Comments for Deadline 2 – Applicant’s response to ExQ1

Sporle with Palgrave Parish Council represented by [REDACTED] RIN – [REDACTED]

Sporle with Palgrave Parish Council (PC) wish to make a number of comments with respect to the following Applicant’s response to ExQ1

Document reference: APP/6.3.2 (Revision 2)

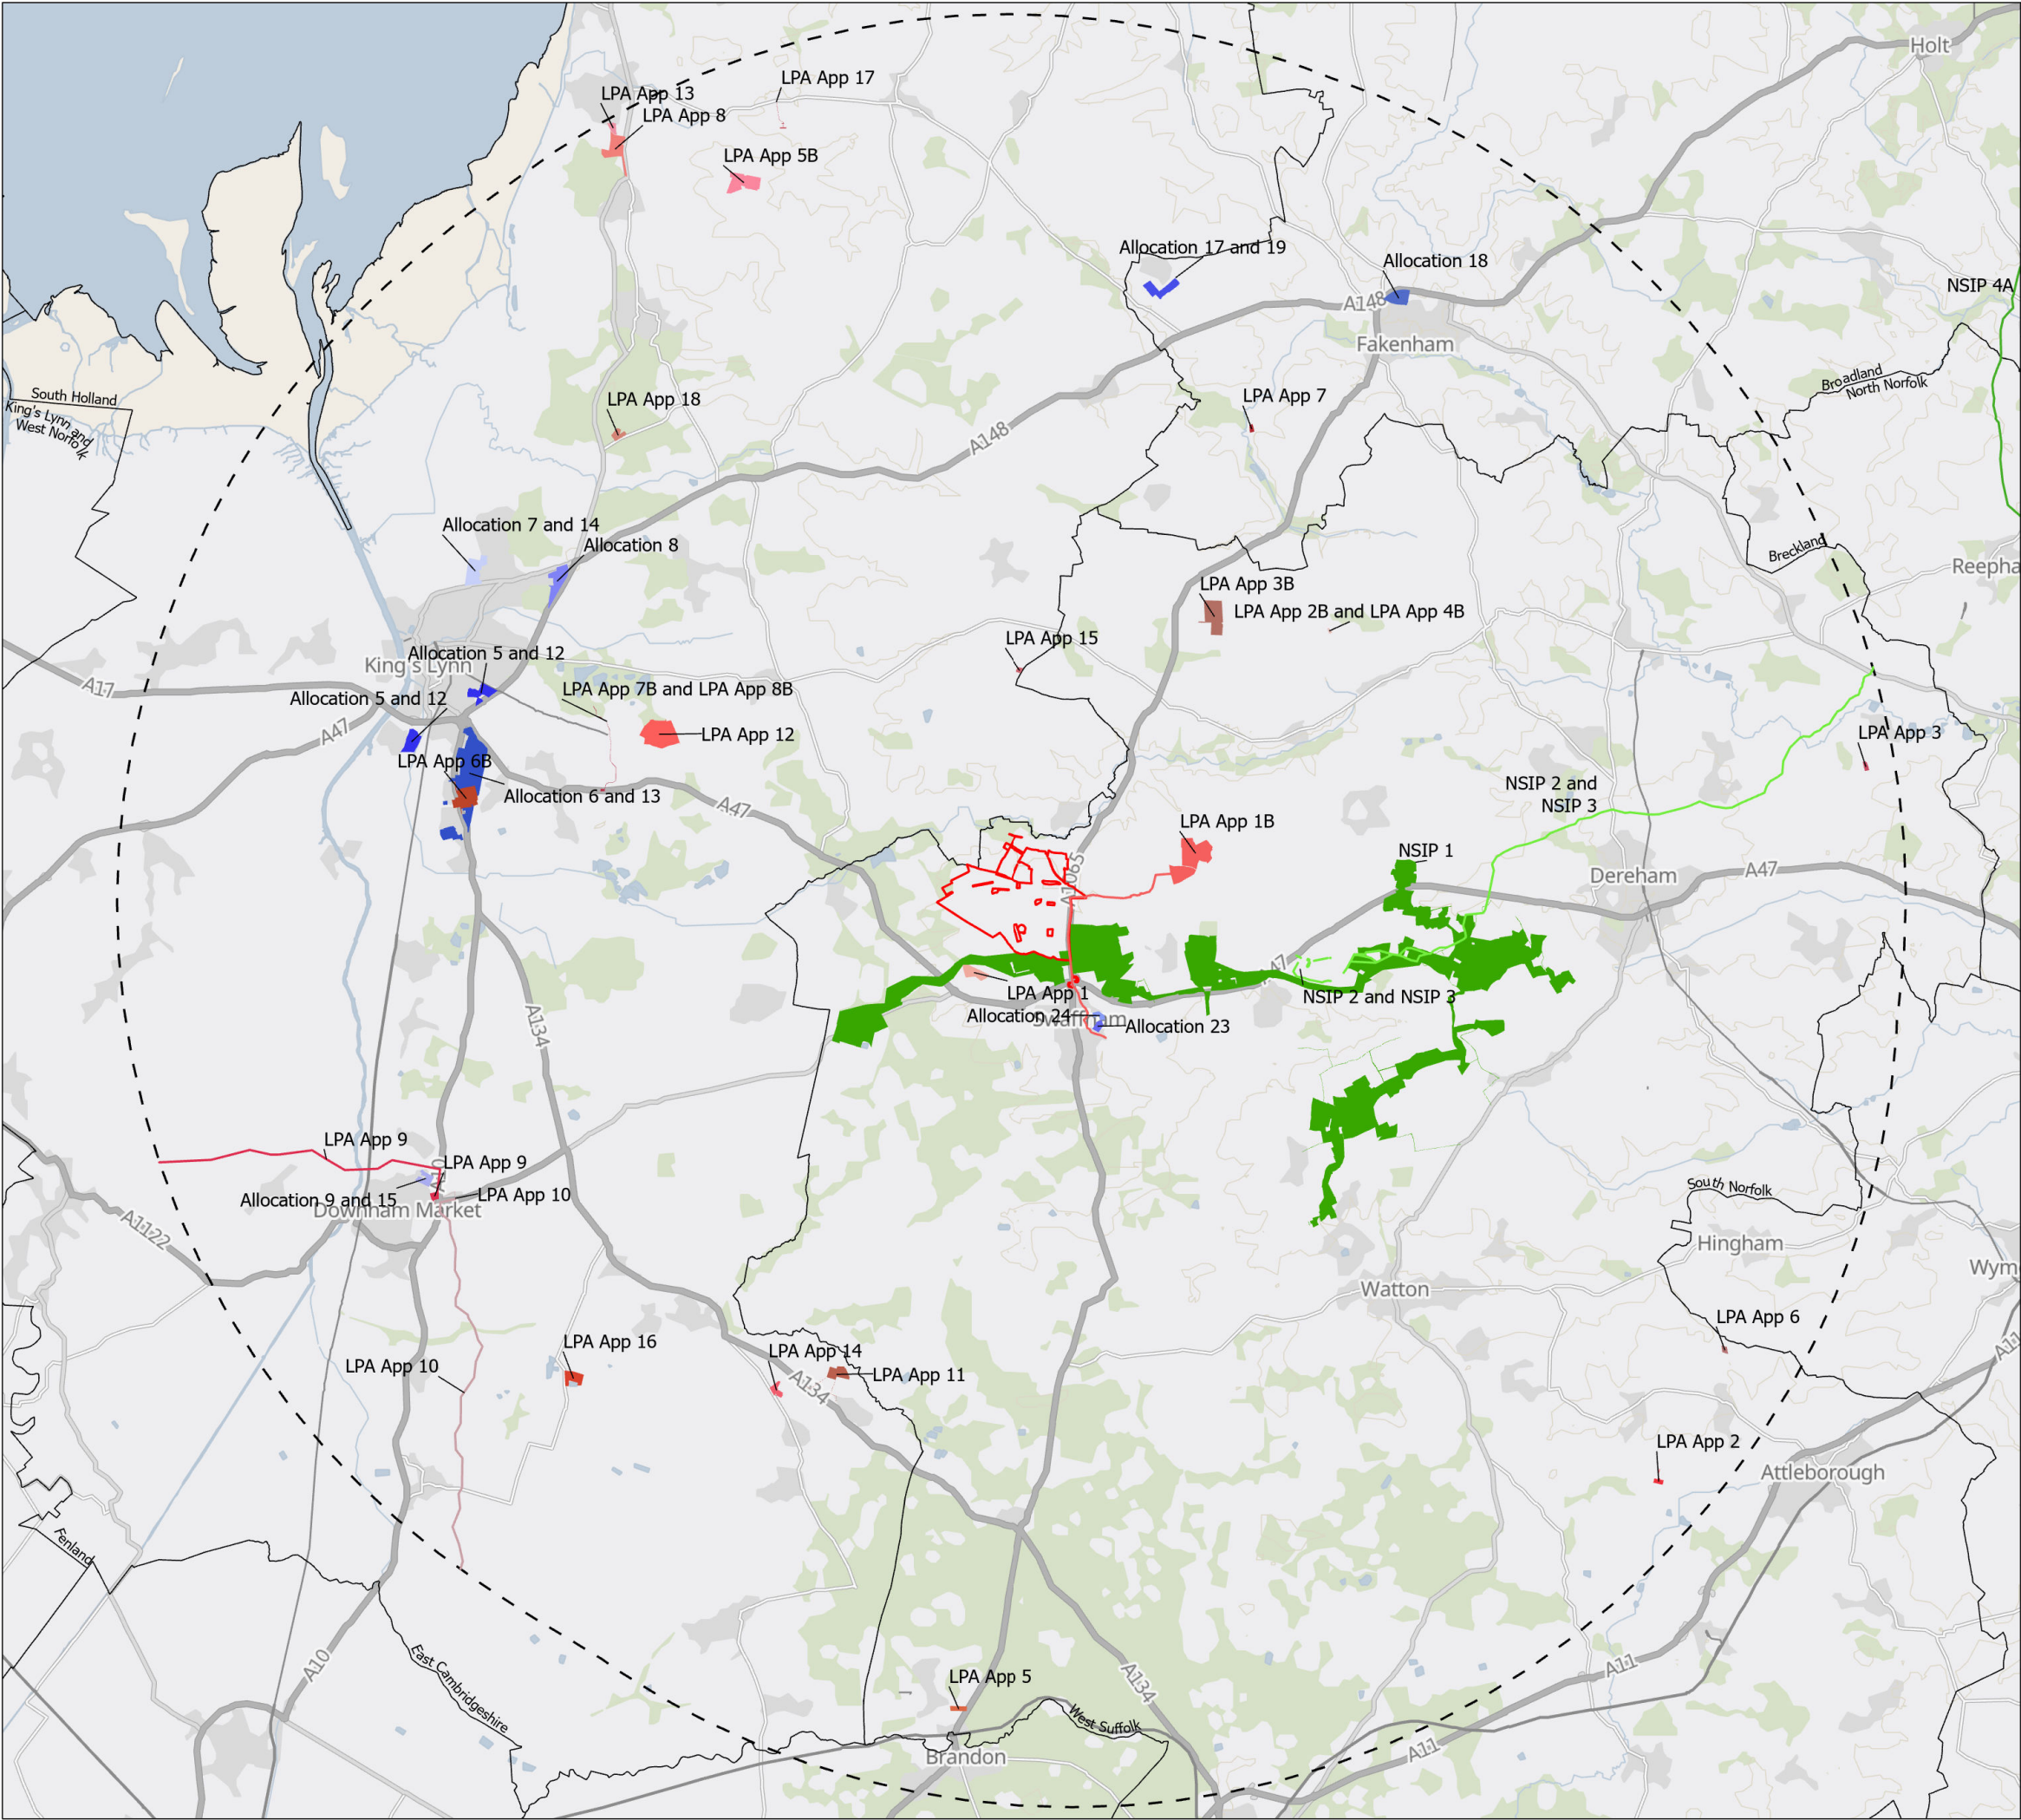
<i>ExQ</i>	<i>Applicant’s Response</i>	<i>PC comment</i>
Q1.0.1	<p>The Applicant has updated and submitted ES Figure 2.1: Cumulative Schemes [APP/6.3.1] at Deadline 1 to annotate clearly each scheme from the short list (to include High Grove Solar Farm) and provide details of any interaction or overlaps. The only overlap between the Order limits for the Scheme and other developments is with High Grove Solar Farm.</p>	<p>Figure 2.1 appears not to show the proposed Shipdham solar and BESS project nor the Jafa project near Little and Great Dunham. Both are in the process of or have gained consent from BDC.</p>
Q2.0.2	<p><i>Cumulative effects for aviation receptors</i> Currently, limited information is publicly available regarding the panel configurations for High Grove Solar Farm. It is understood that the Preliminary Environmental Information Report for High Grove Solar considered options for both fixed south facing and single axis tracking panels for that project.</p> <p>The only panel areas of High Grove Solar Farm which could produce cumulative effects for aviation receptors would be the central panel areas, which are directly adjacent to the Scheme and border High Grove Solar Farm to the south and east. The south-eastern section of the Site which borders High Grove Solar Farm is not predicted to be visible to the ATC tower, and there are therefore no cumulative effects predicted upon the ATC tower. Cumulative effects could be possible towards the approach paths and visual circuits at RAF Marham, but this would require the Scheme and High Grove Solar Farm to share the same panel technology. Indicative modelling has been conducted for this scenario, which indicates that any glare would be within the same intensity classification, and therefore impacts are not considered to be of a greater severity due to cumulative effects.</p>	<p>This highlights the importance that PC representations have put on the need for speedy action during this examination to engage with High Grove to deal with the cumulative impacts caused by the increasing likelihood of construction taking place at the same time of both the Drovers and High Grove.</p>
